Jean Fraser - Re: 133 York Street/Harborview Flats

From: Susan Kaplan <birmanmom@gmail.com>
To: Jeremy Benn <jeremy@joeflynnrealestate.com>
Date: 9/24/2013 6:01 PM
Subject: Re: 133 York Street/Harborview Flats
CC: Seth Page <sxp@earthlink.net>, Elliot Vrana <elliott.vrana@gmail.com>, Er...

EROSION CONTROL AND LANDSCAPE PLAN

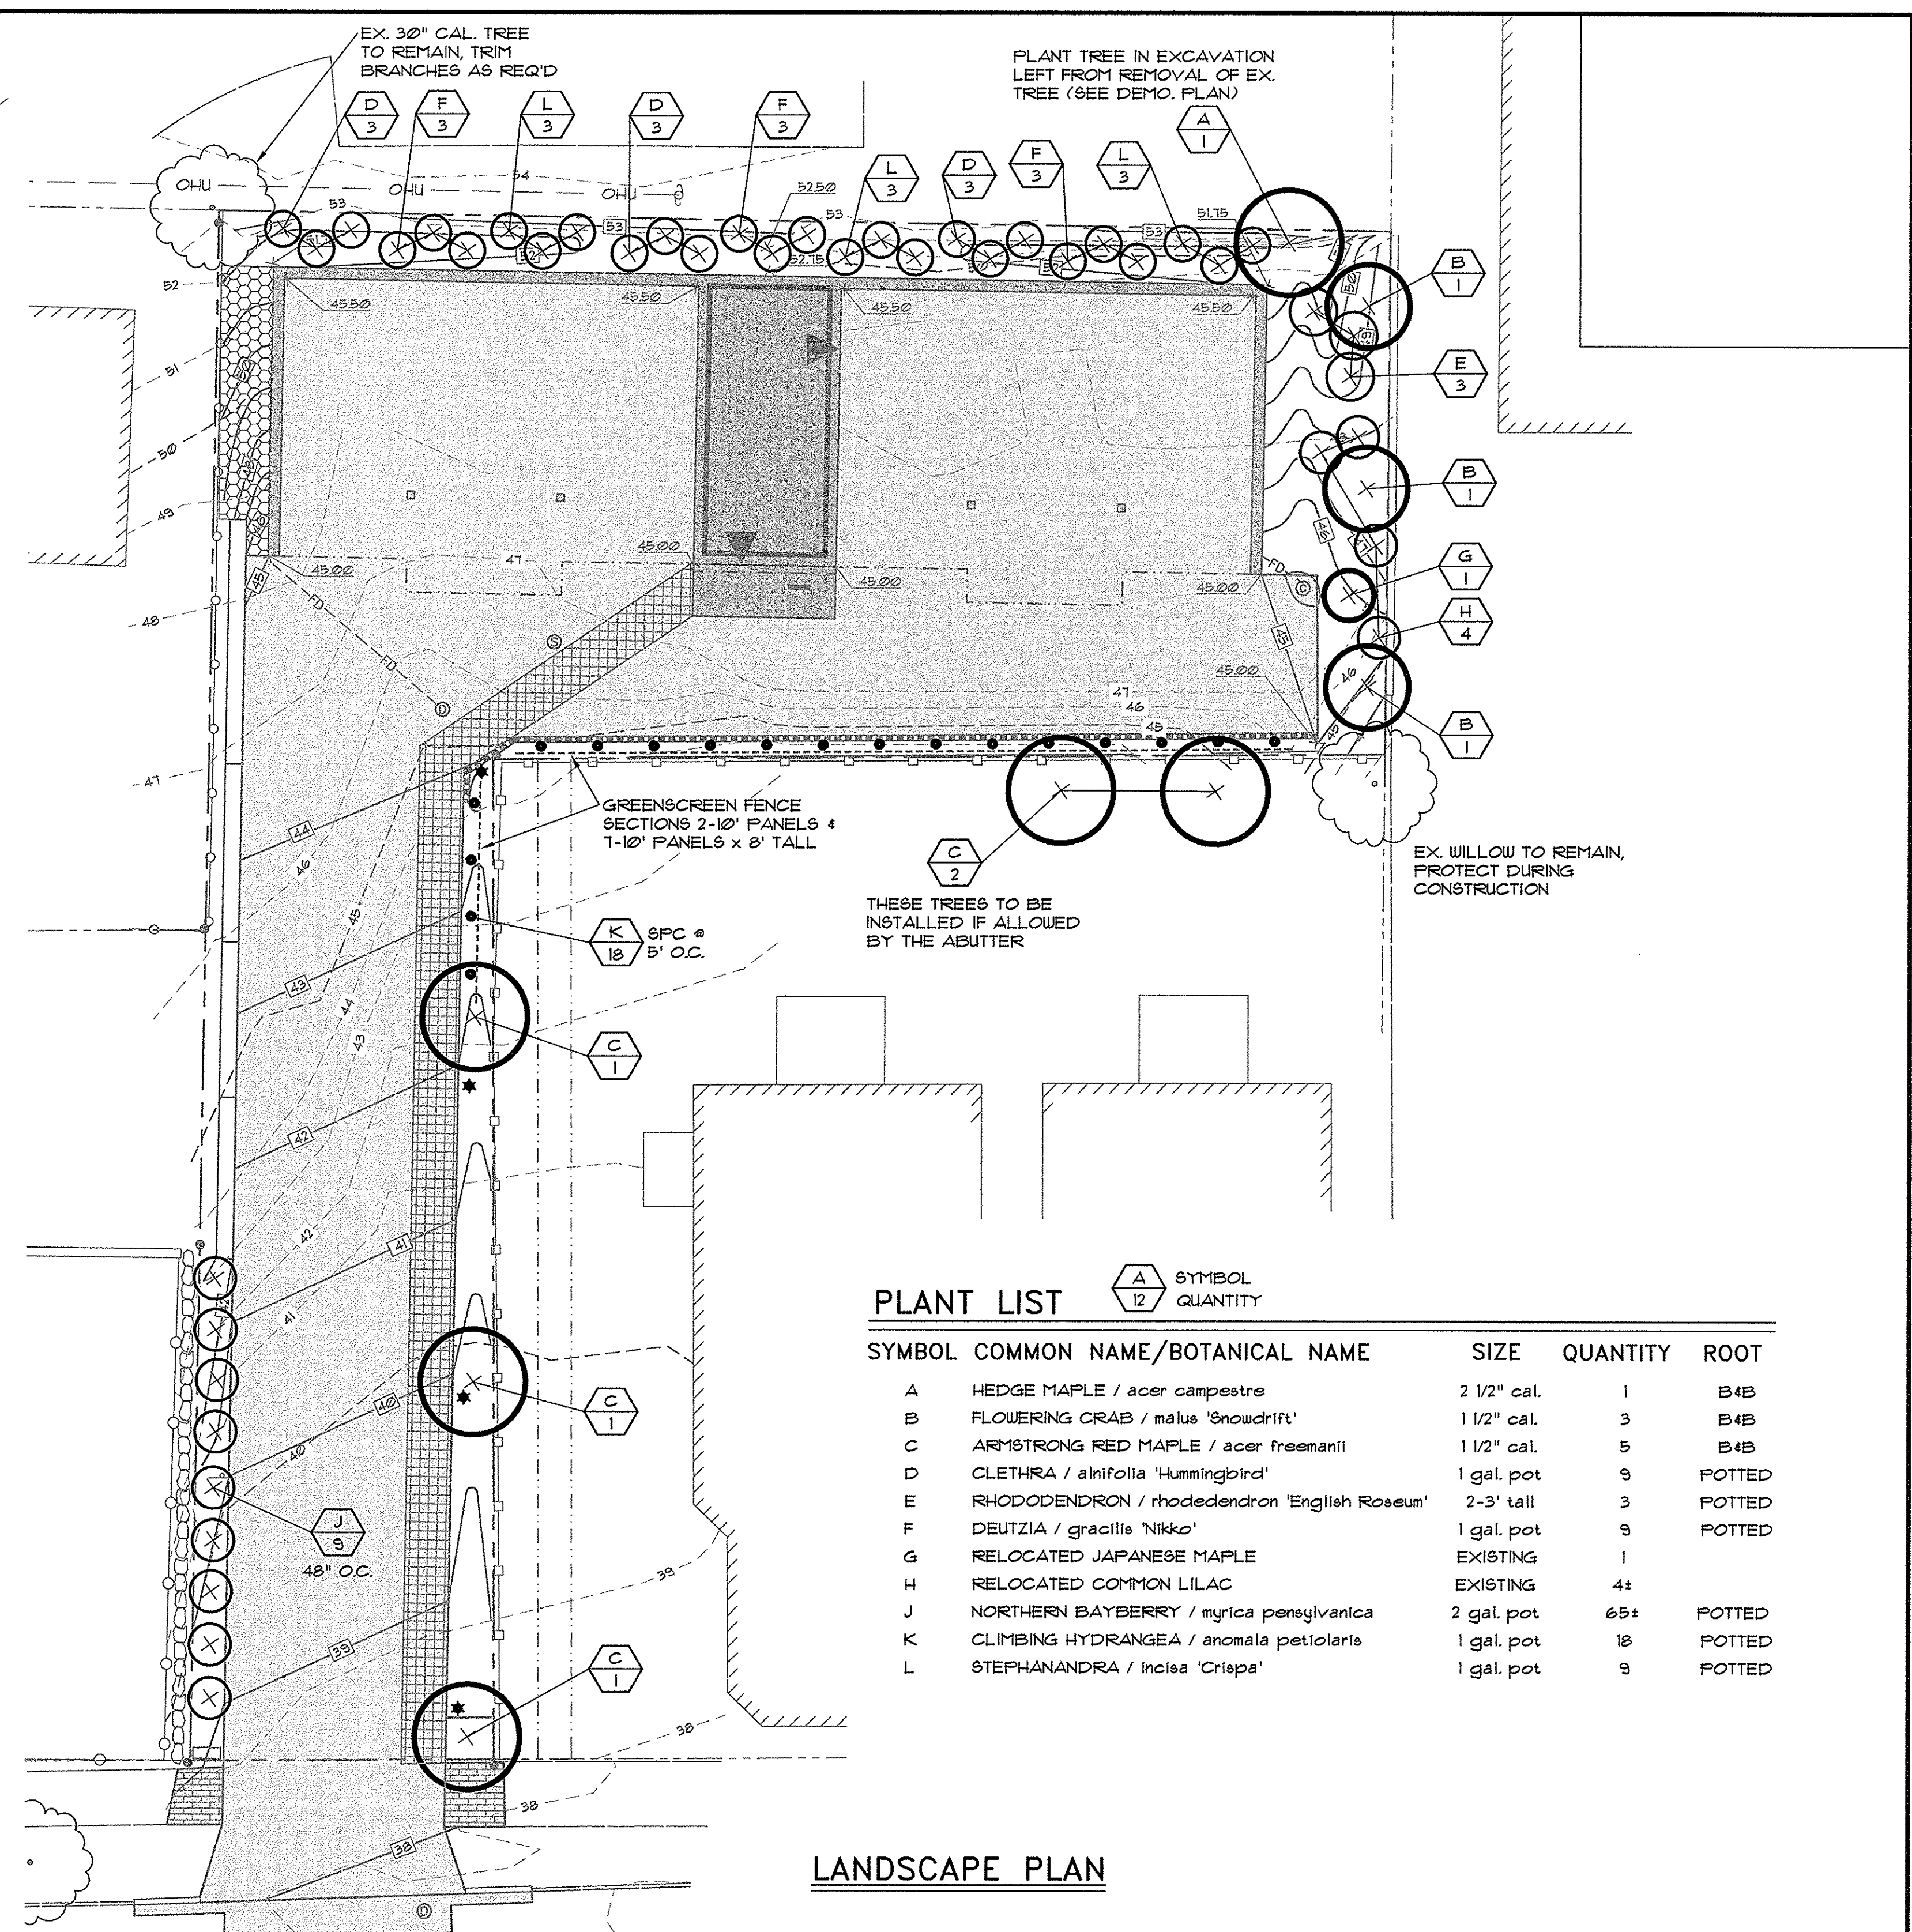
Below is an updated image with the green wall highlighted in yellow. The areas noted in blue (below) are our primary concern; hence the placement of the green wall is puzzling to me. Perhaps our concerns were not clearly stated.

AS the plan sits, the headlights from cars that are backed into your parking area will shine directly into the first floor condos (in blue) at the Flats. This unscreened area is noted with the red arrows above. The green wall and trees (as they are currently proposed) will not adequately address our concerns.

- 1) In your present design, is the green wall only planned for the section that is highlighted in yellow in the image below (the corner area)?
- 2) If YES, what provisions (beyond the trees you cited) have you made for affording the Flats screening and privacy from the parking area?

3) And finally, do you have any plans for providing privacy or screening to the adjacent Townhomes building?

I see your concerns about the headlights as illustrated by the red arrows. I have asked the engineer to update the site plan to show a "green wall" to continue all the way across the fence. I will keep you updated on the façade.

1) The green wall goes beyond what you have highlighted, it is represented by the dashed line. It goes to about where the front door is located and further down the driveway.

2) The additional provision is in fact the two trees on the plan – this was suggested by the city arborist. We have added the trees and green wall to help with the privacy concerns.

3) The extra privacy for the town homes is provided with the additional 12 trees and shrubs as detailed on the plan.

I attached an updated site plan that illustrates the proposed trees and "green wall" addressing the planning board and abutters concerns. The plan identifies the location, species, and size of the plantings. I spoke with the architect this afternoon, he is working on the façade design. I will forward you the "re-worked" design as soon as it is available.
